We have the following comments regarding condition 9:

TYPICAL PERMEABLE DRIVEWAY SHOWING DRAINAGE FEATURES
(TANKED SUB-BASE CONSTRUCTION)
(1:20)

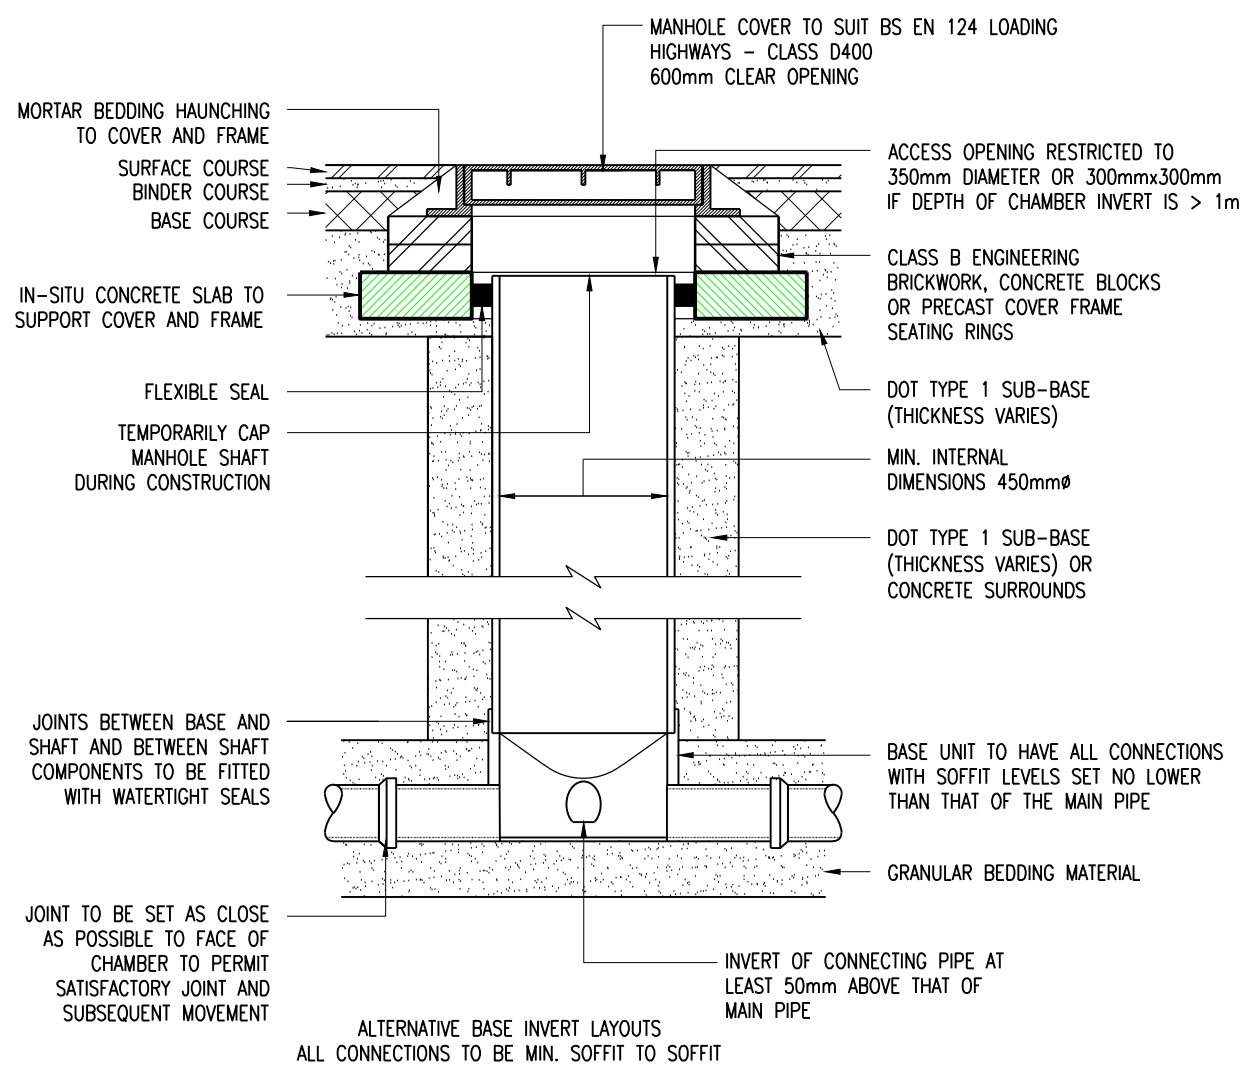
1. Please can a site specific construction detail drawing of the hydrobrake be provided.
2. Please adjust layout to include silt traps prior to all connections to permeable paving on plan.
3. Please provide finish and formation levels of permeable paving.
4. Please provide dimensions and construction detail for permeable pipe through sub-base.
